RE: LPF-22-00004 Suncadia Phase 2 Division 7 Final Plat Comment – Applicant Responses

Suncadia Resort LLC is submitting this letter in response to the transmittal of final plat comments regarding the Suncadia Phase 2 Division 7 Block 1 Final Plat LPF-22-00004. Below you will find responses to each of the comments. Please let me know if there are any questions.

DATE: 2022-06-29 JOB NO. 998-852-021-0003
DRAWN BY: C.A.F./R.F.G. SHEET 4 OF 15

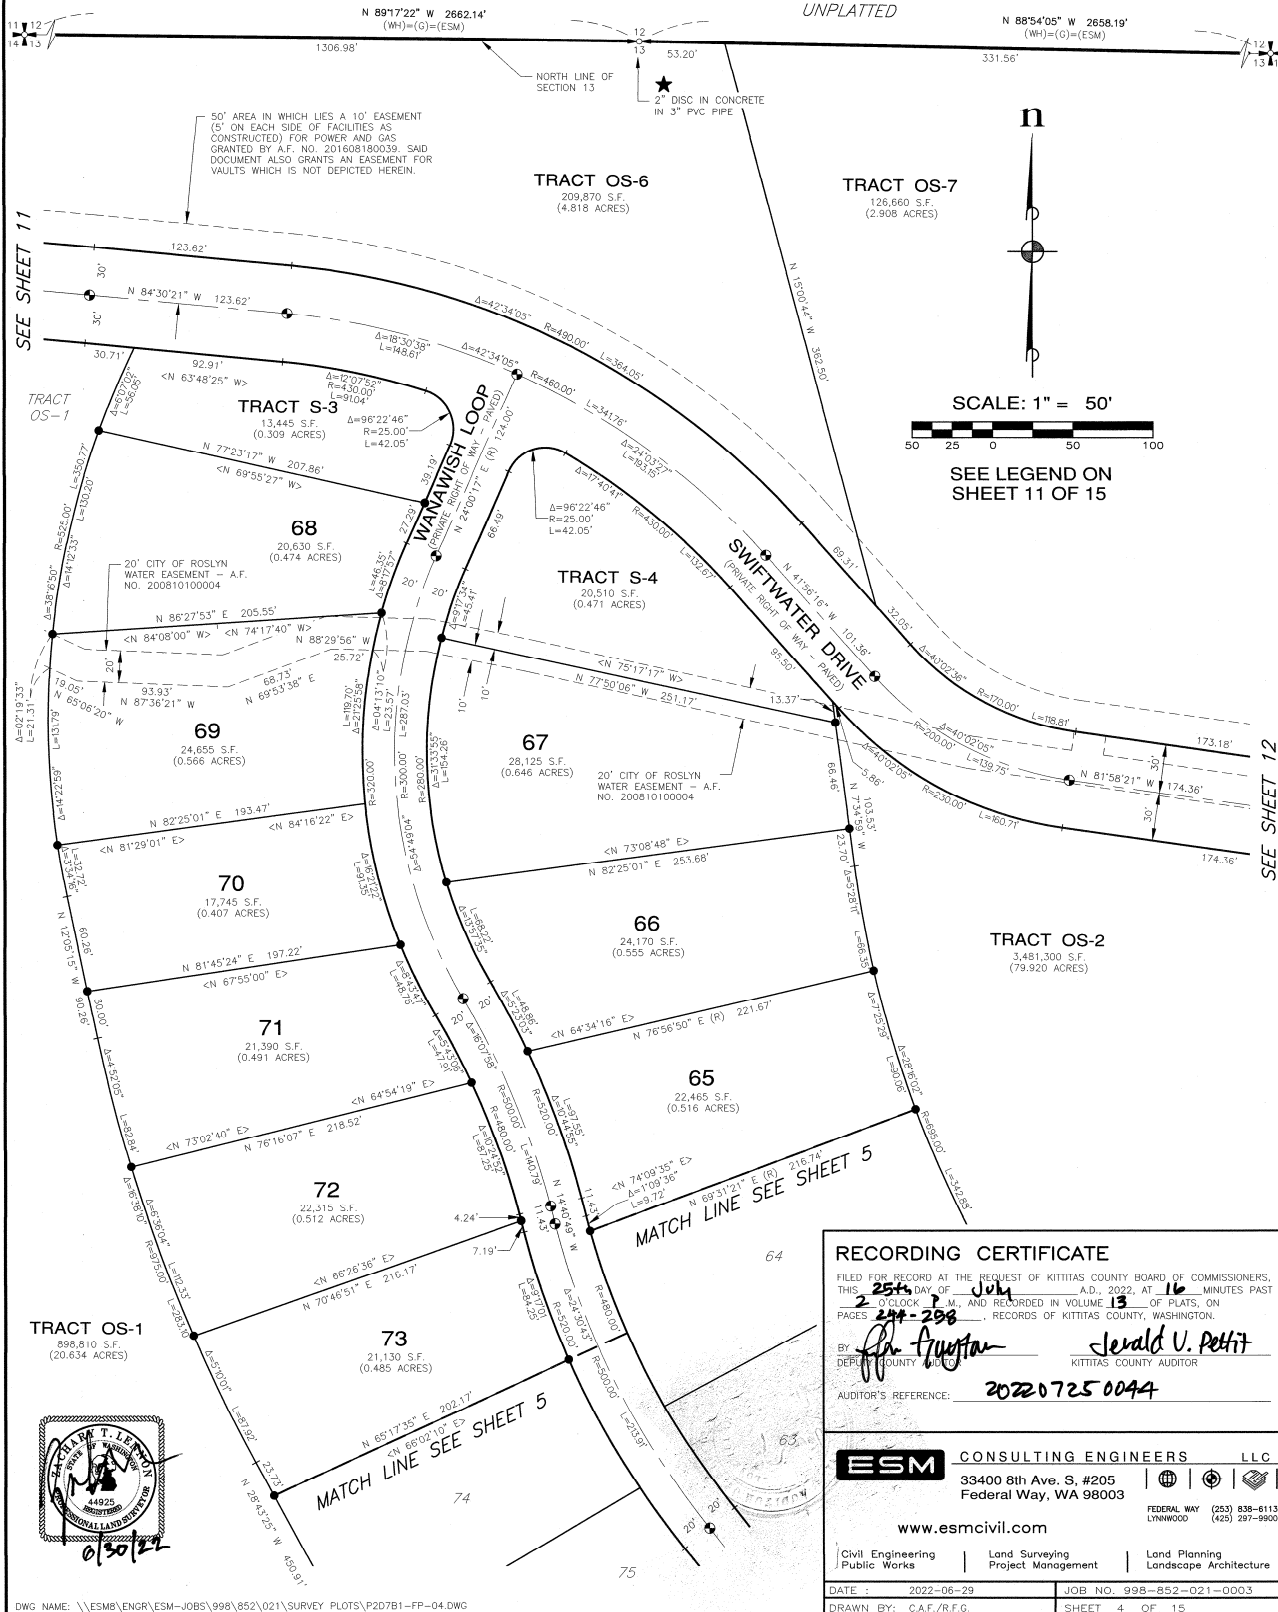
- 1. Sheet 4 – The North line of NW ¼ of Section should show a “tick mark” to show the line limits.*
- 2. Sheet 4 - The North line of OS-7 should show a bearing. While this is available on other sheets, it*

is somewhat difficult to find.

Applicant Response: Revisions made to the final plat documents that are attached digitally to this correspondence.

DATE: 2022-06-29 JOB NO. 998-852-021-0003
DRAWN BY: C.A.F./R.F.G. SHEET 6 OF 15

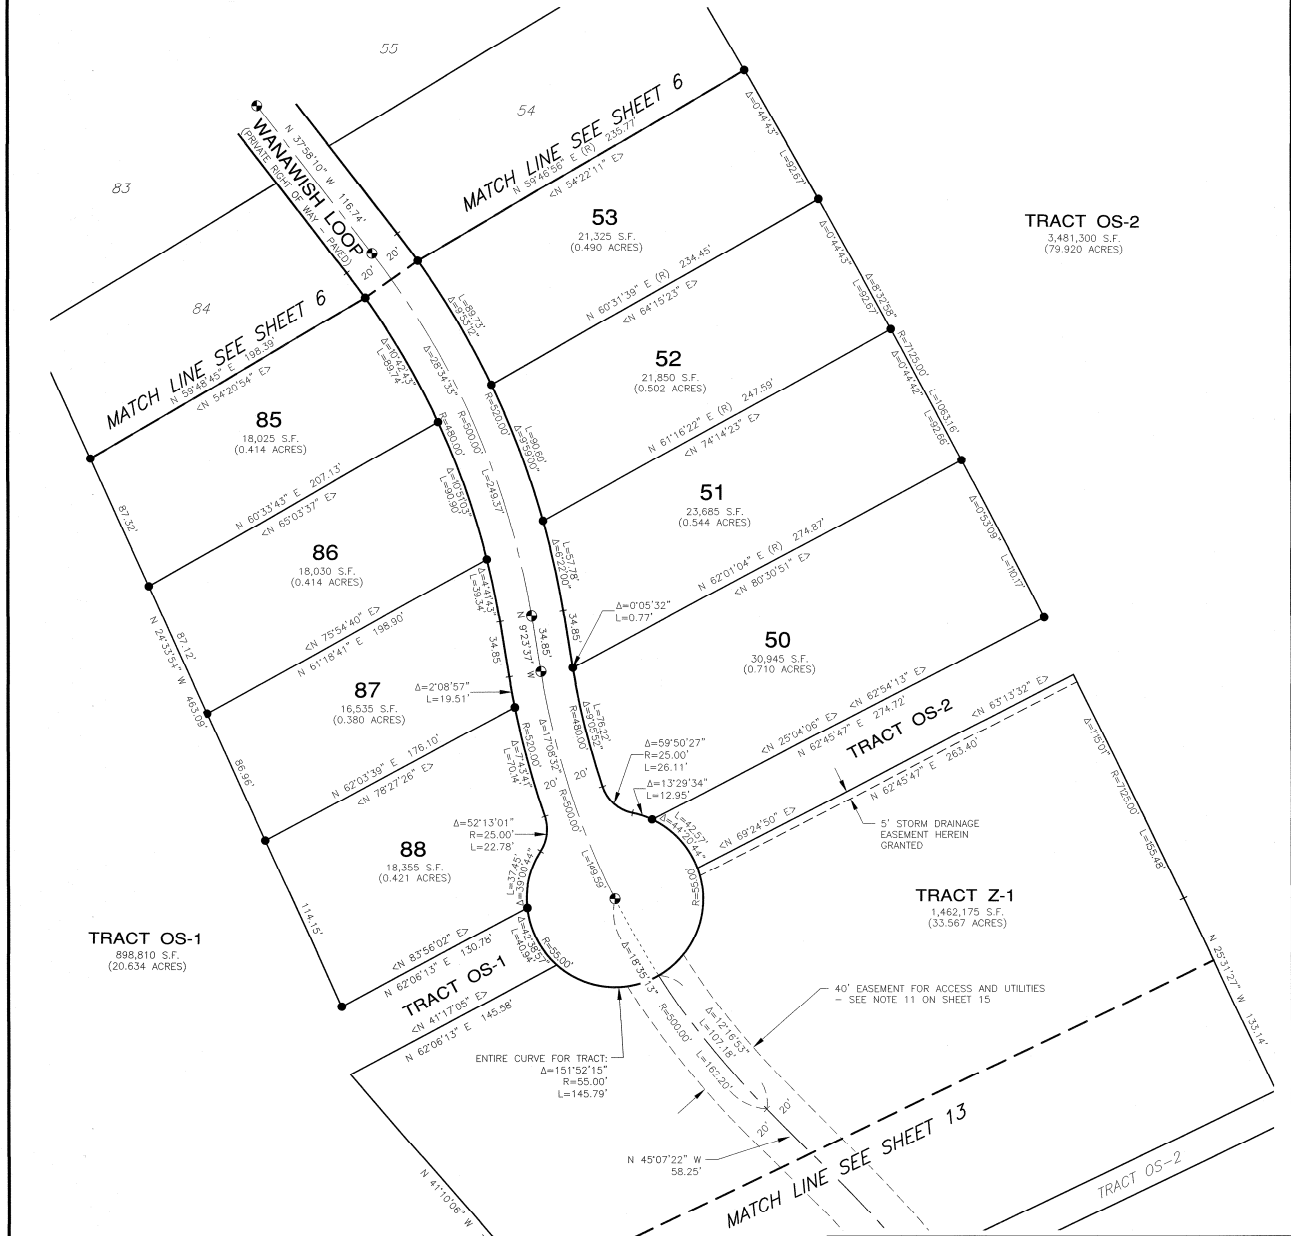
3. *Sheet 6 – The area of Lot 81 does not match the Lot Closure report.*
4. *Sheet 9 – The area of Lot 7 does not match the Lot closure report.*
5. Sheet 10 – The area of Lot 11 does not match the closure report.
6. Sheet 11 – Please label Tract OS-2 on this sheet.
